Mr. David Gibson  
Team Leader  
Social Infrastructure Assessments  
Department of Planning and Environment  
GPO Box 39  
Sydney NSW 2001

**New Maitland Hospital (Concept Proposal and Stage 1), Metford Road, Metford (SSI 9022)  
Notice of Exhibition**

## **TAB A**

## 4-2 VEHICULAR CIRCULATION

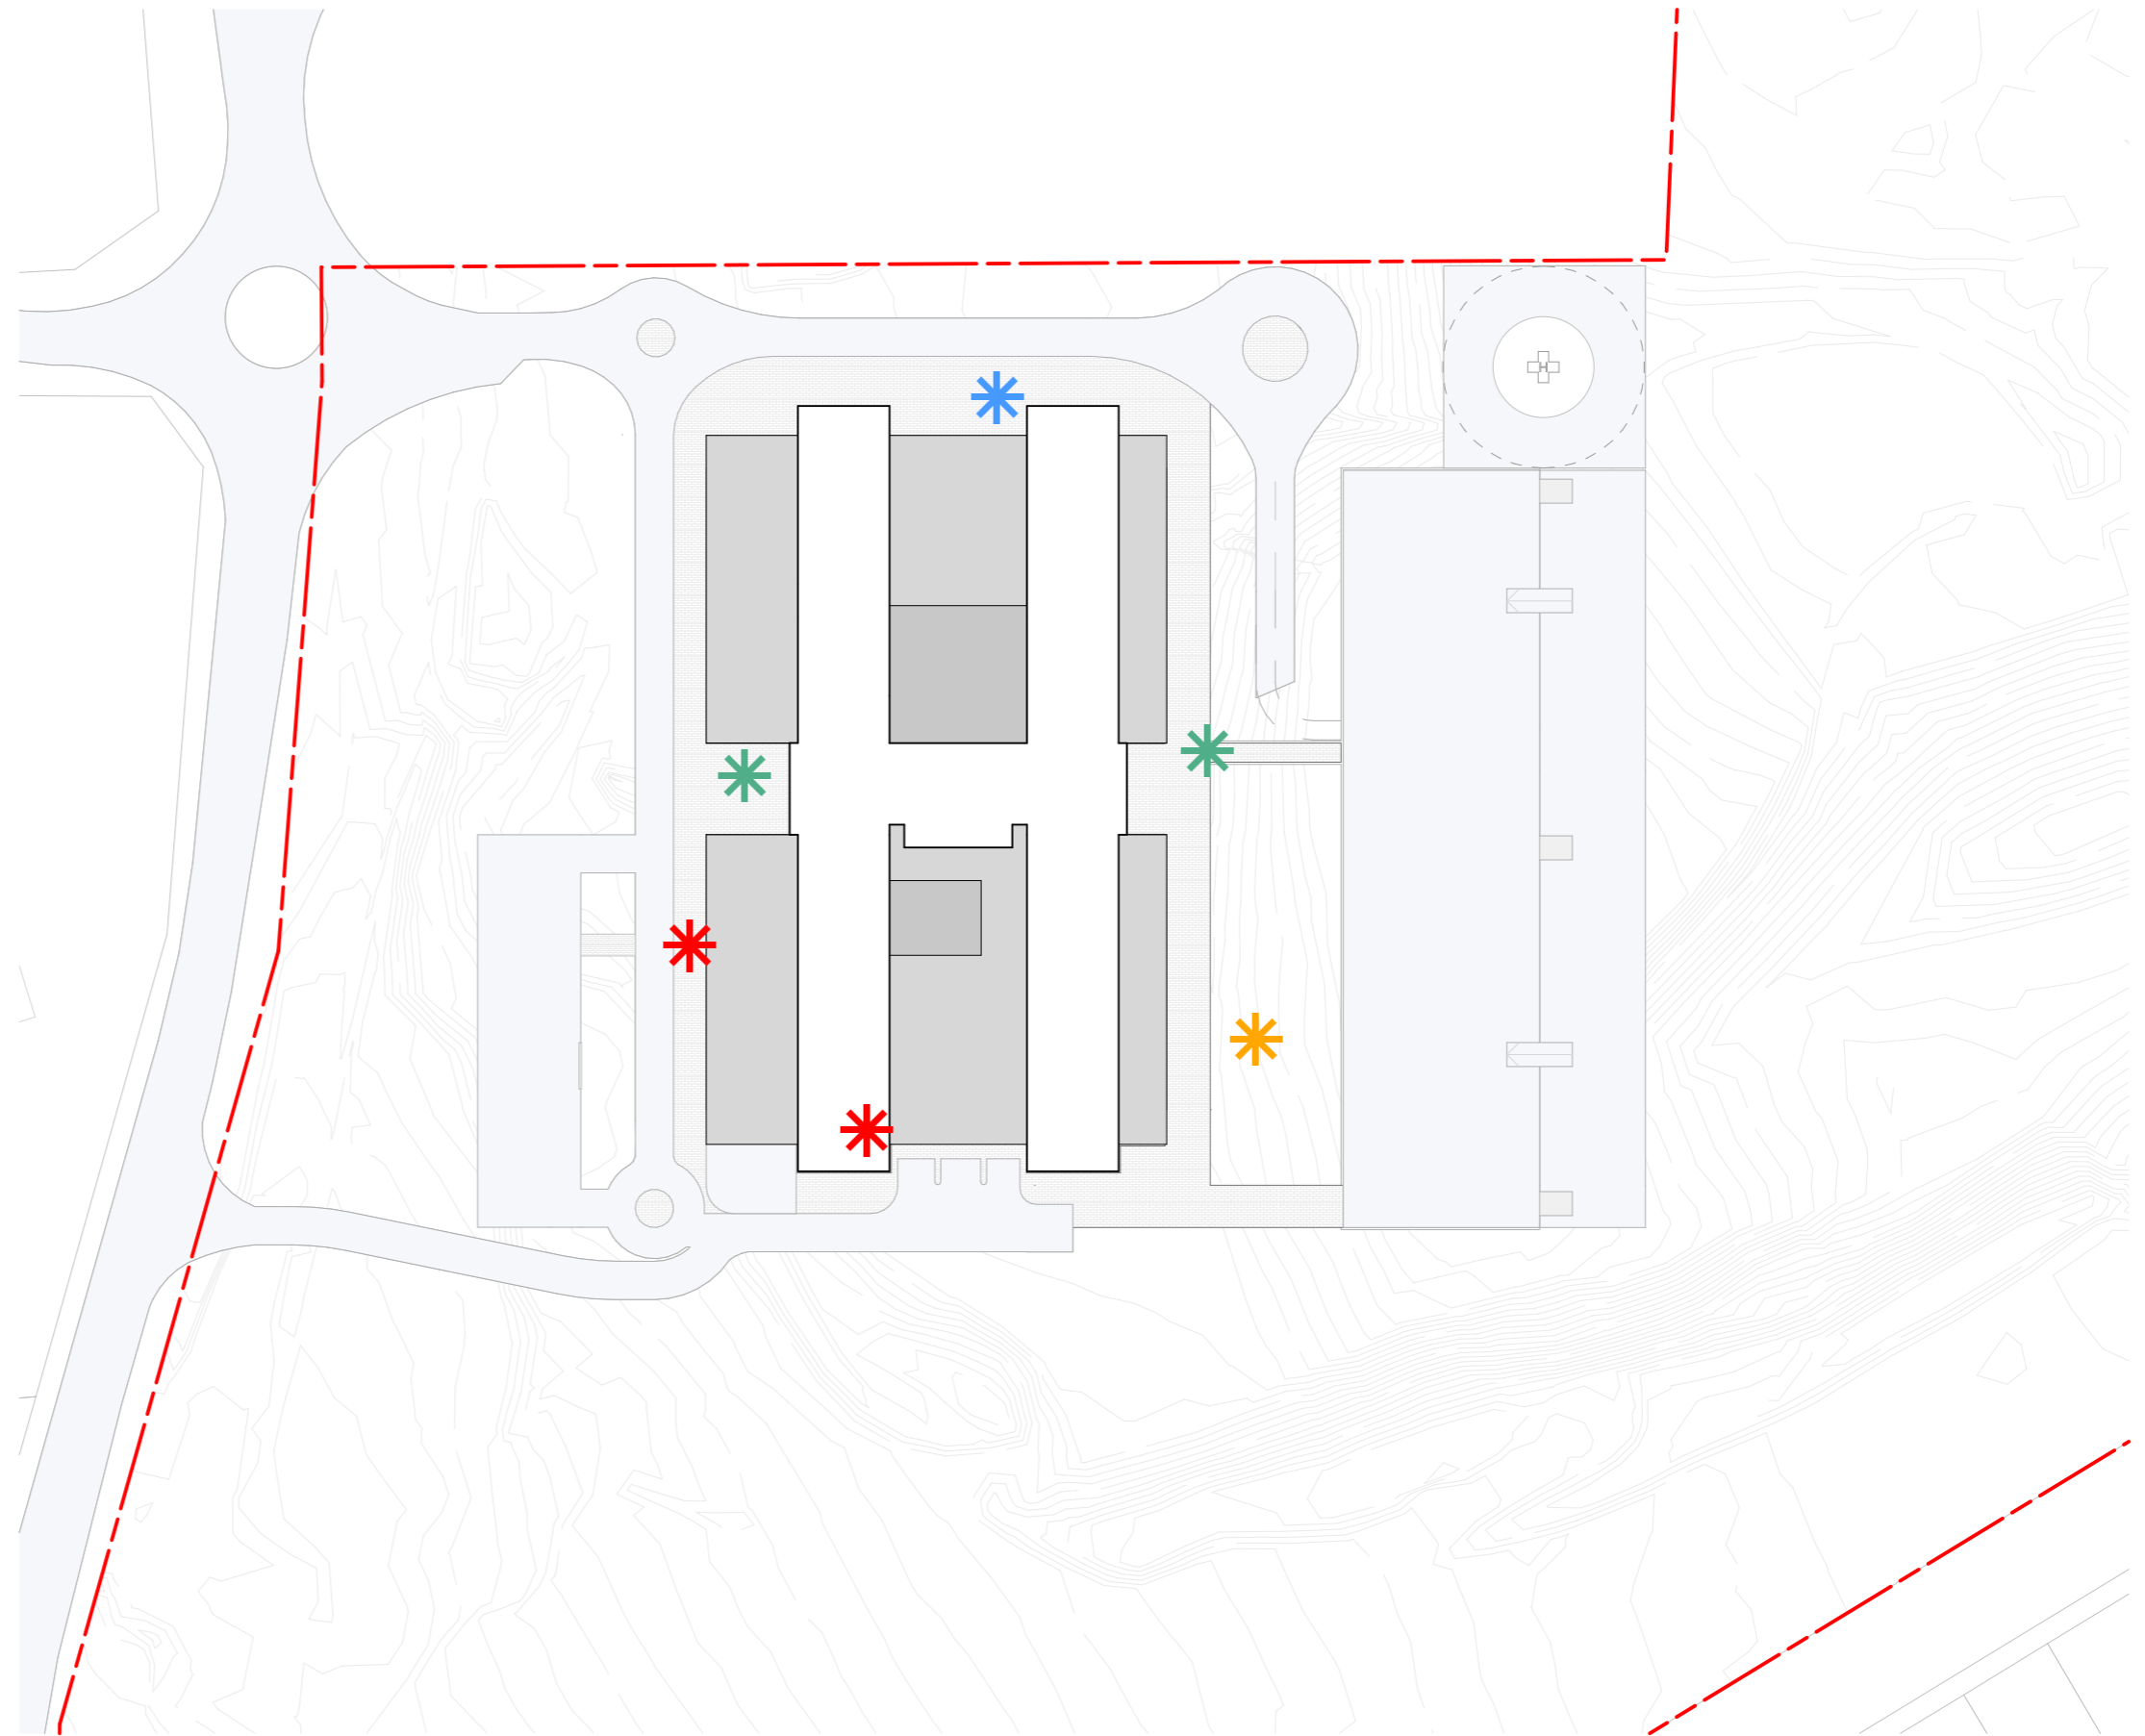
Prior correspondence dated 10 April 2018 detailed basic requirements to ensure the internal road environment provided safe, efficient and operationally viable infrastructure for buses. To satisfy this requirement, provision of roads built with 3.5m travel lanes, a swept path analysis conducted by a 14.5m non rear steer bus and a DDA compliant bus stop located on the hospital side of the internal road is necessary. These requirements are to be considered in the Stage 1 concept plan.

The Traffic Impact Assessment (TIA) notes that Metford road and northern internal roundabouts have been designed to accommodate bus movements, however does not provide a swept path analysis of this.

- Provide a swept path analysis conducted by a 14.5m non rear steer bus.
- Confirm the internal road network is to be built with 3.5m travel lanes and the bus stop will be DDA compliant.

The EIS notes that due to the high level of activity expected from NMH a significant demand for public transport will be generated. As such, it is proposed that sufficient allocation of space is reserved to accommodate three buses in the bus bay at any given time.

Reserve a sufficient allocation of space to accommodate three buses in the bus bay at any given time.
